# Applicants' Response to Deadline 2 and 3 Submissions

The East Midlands Gateway Phase 2  
and Highway Order 202X and The East Midlands Gateway  
Rail Freight and Highway (Amendment) Order 202X

**(DOCUMENT DCO 7.13 / MCO 7.13)**

<b>Version</b>	<b>Date</b>	<b>Status of Version</b>
0	June 2026	Deadline 4

Drawing No.	<b>EMG2-BWB-HGN-XX-DR-H-0101</b>	Revision	<b>P11</b>
-------------	----------------------------------	----------	------------

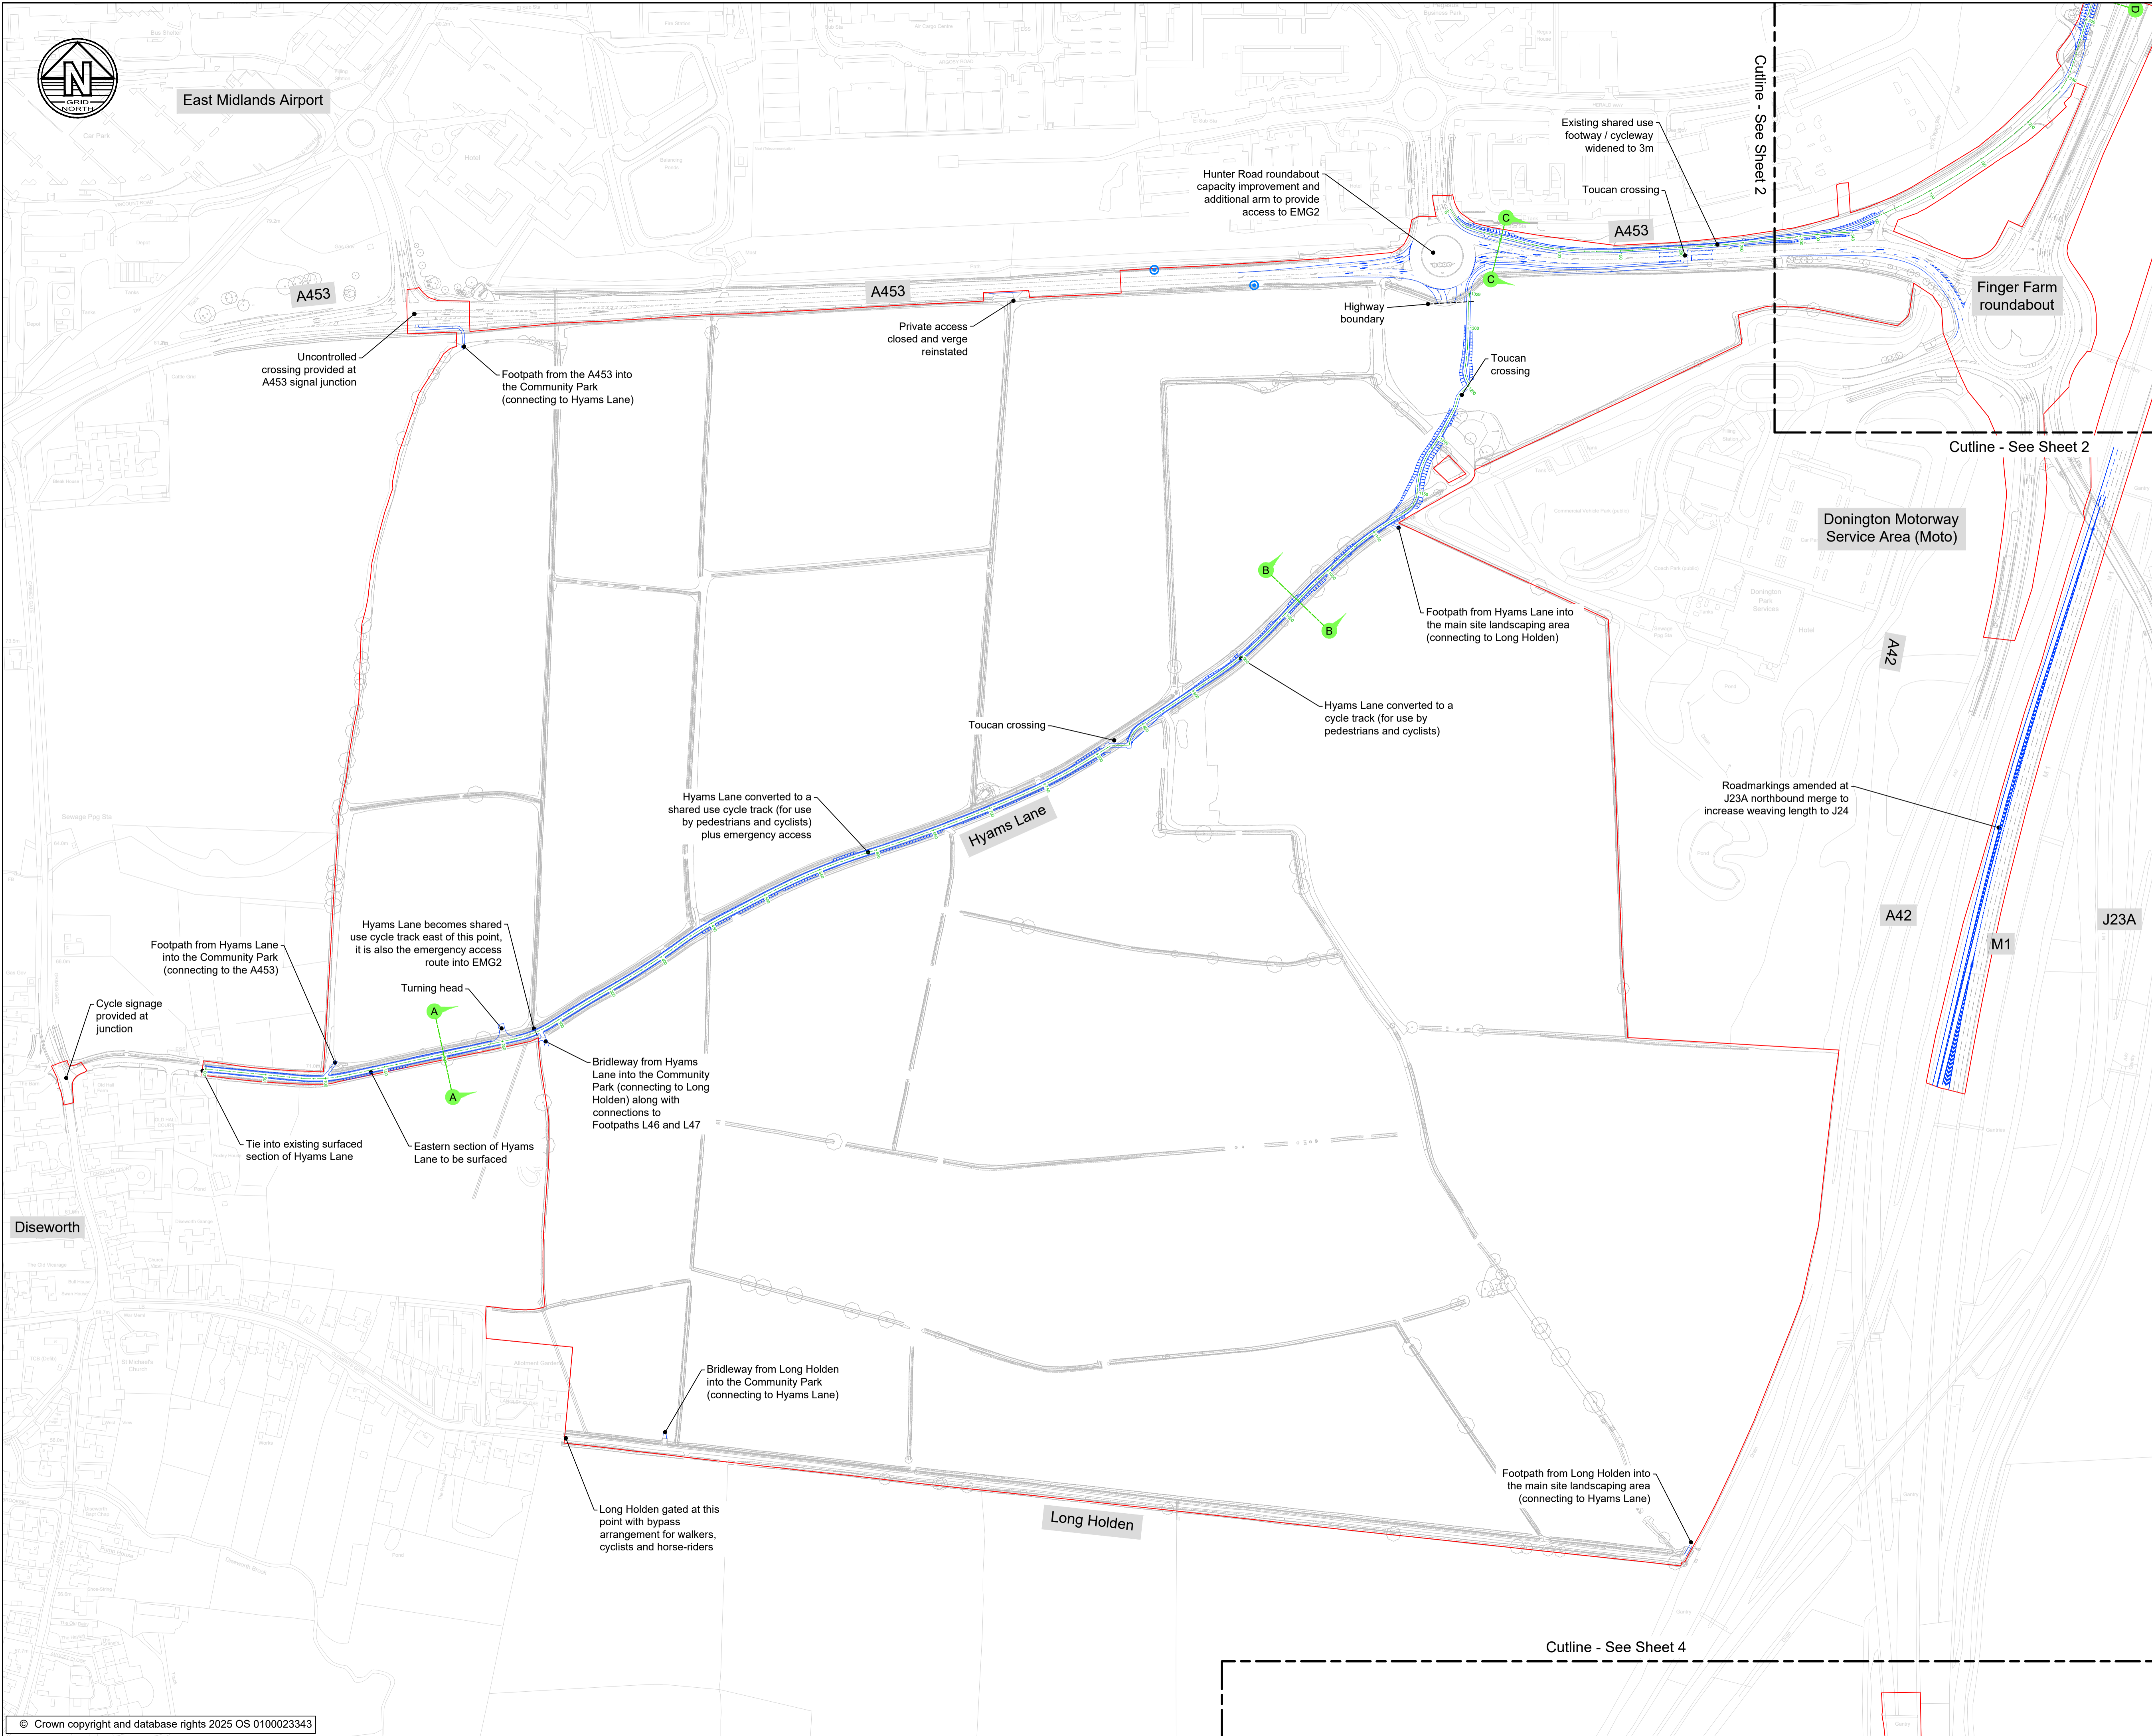
5.	<p>Highway Plans General Arrangement Sheet 1 of 4</p> <p>LCC reserves its position on the highway design on the LRN pending resolution of PRTM2023 modelling and final understanding of the impacts on the LRN as set out in its Written Representations [REP1-085]. LCC also notes its comments in the responses to the EXP first questions [REP1-088] and Local Impact Report [REP1-084] regarding Works no 15 (EMA junction uncontrolled crossing).</p>	See the Applicants' response to the Deadline 3 submission below and the response at point 2 above in relation to Works No. 15.

L57 SHARED USE CYCLE TRACK PROFILE
SCALE: H 1:2500, V 1:500. DATUM: 55.000

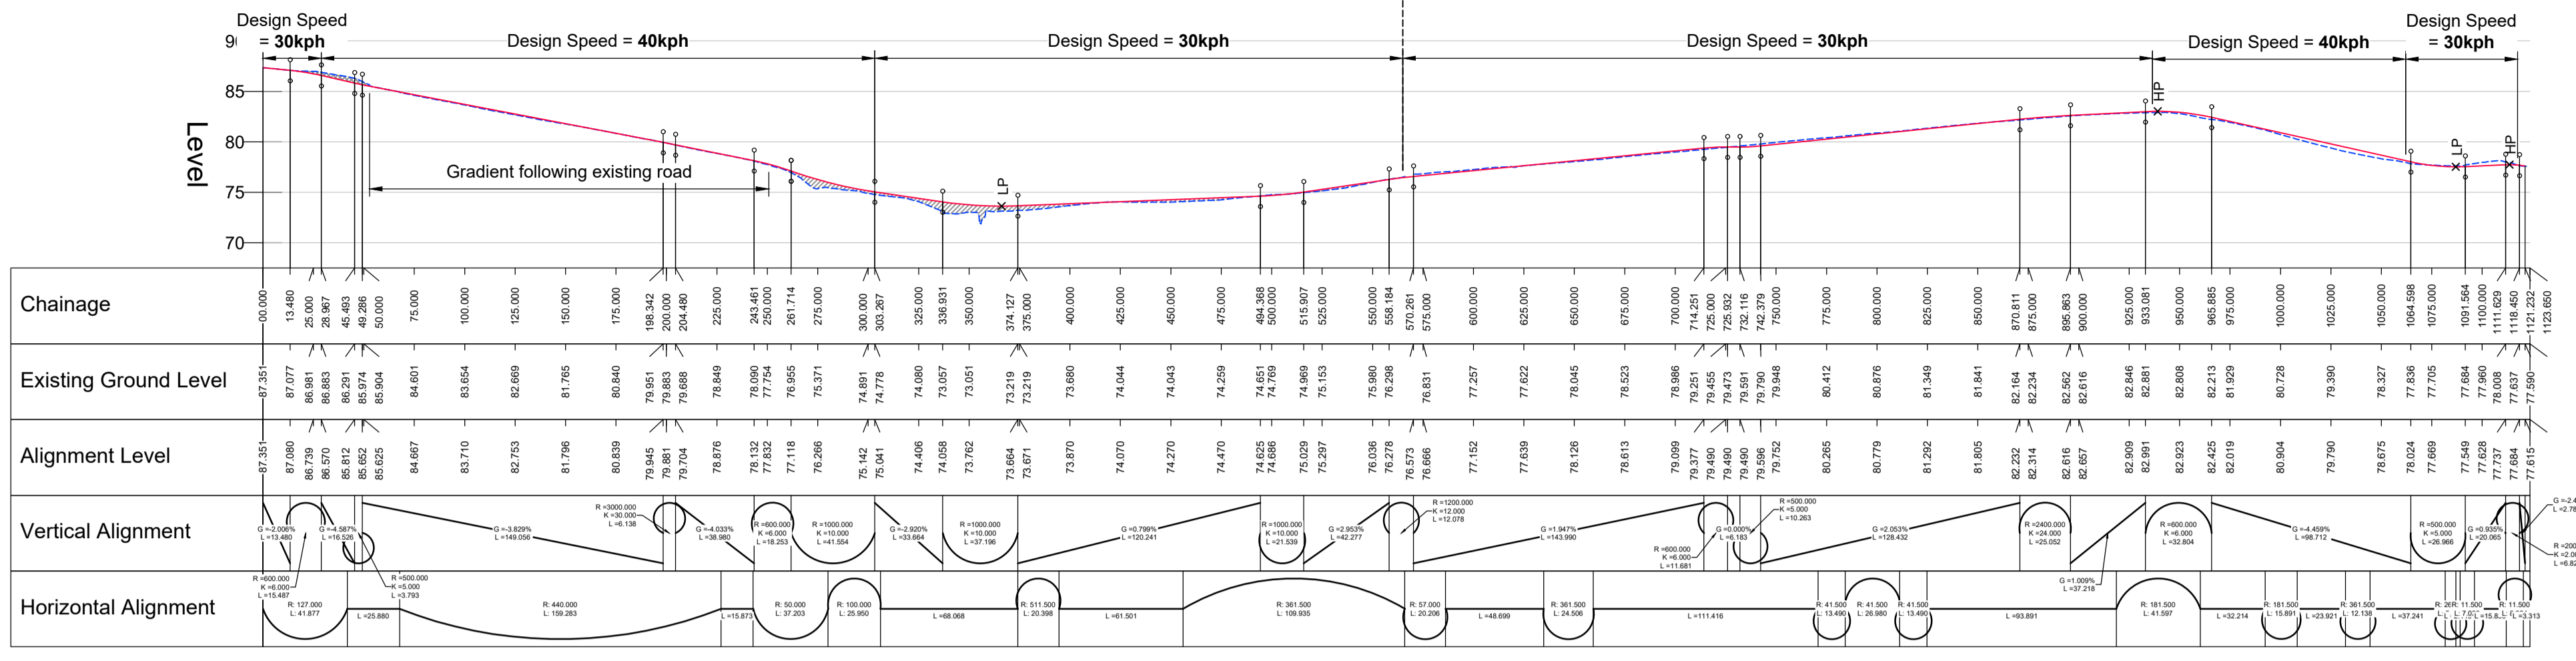
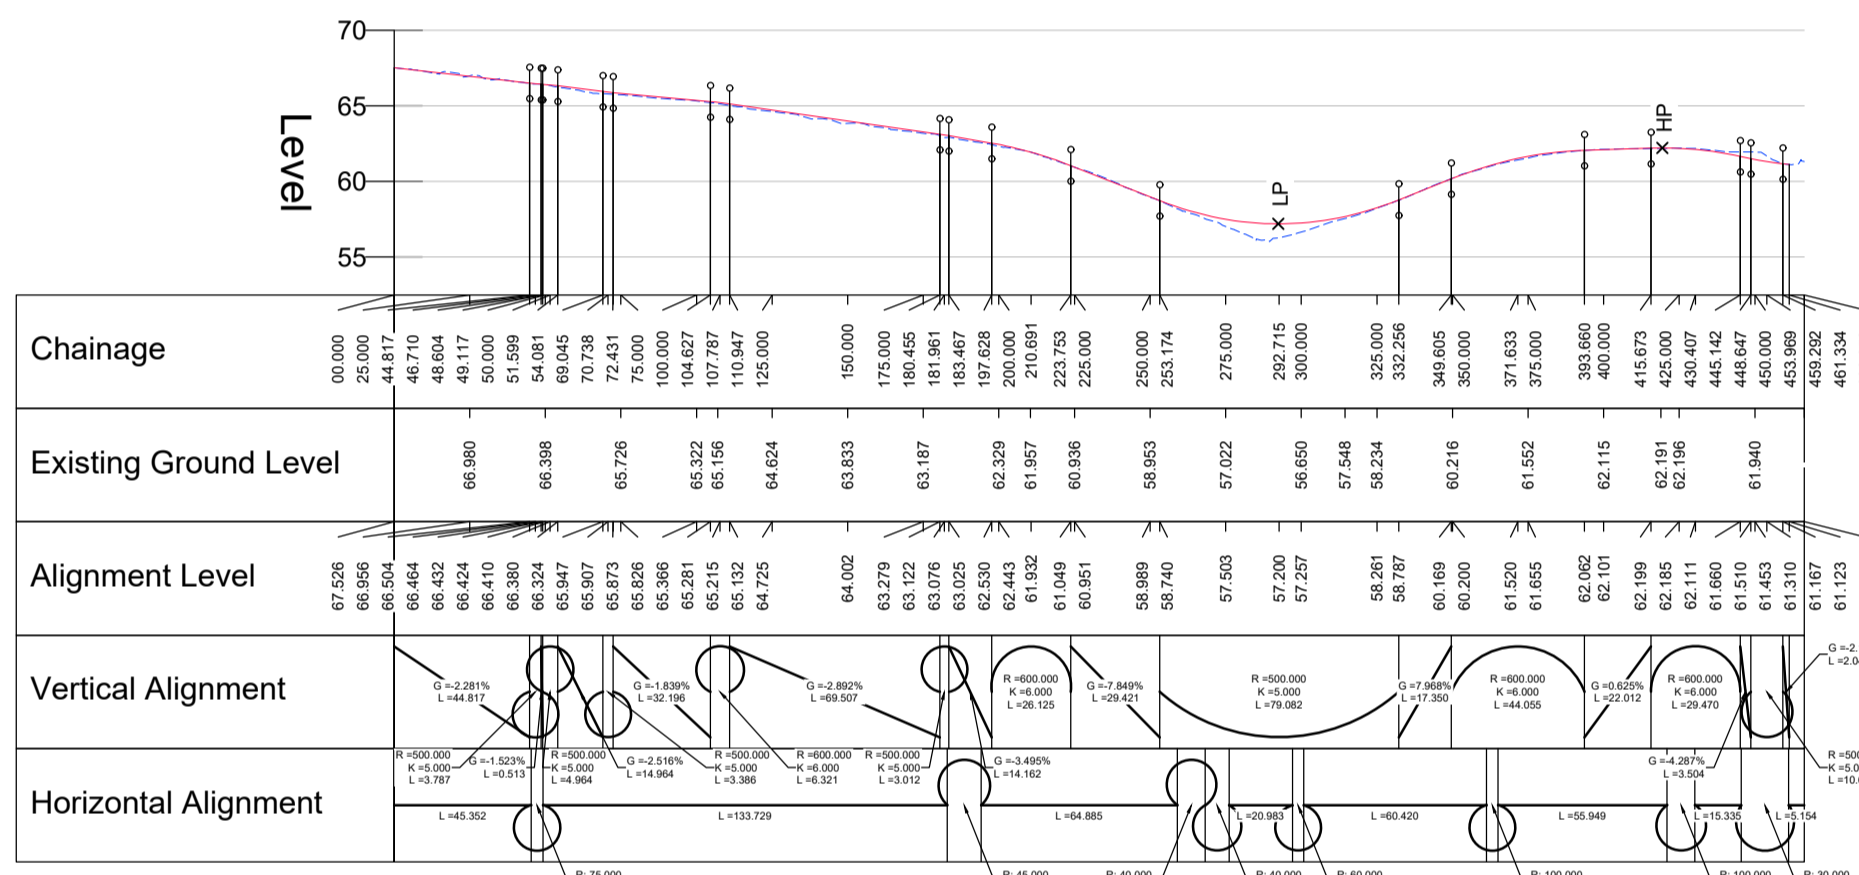
4.	<p>Access and Rights of Way Plans Sheet 2 of 2</p> <p>With regard to public footpath L57, LCC has raised concerns over the mechanism to allow cycle access in conjunction with a PRow to ensure no loss of the PRow from the definitive map in its dDCO comments [REP1-087] submitted at Deadline 1.</p>	This has been addressed in the same way as confirmed in point 3 above.
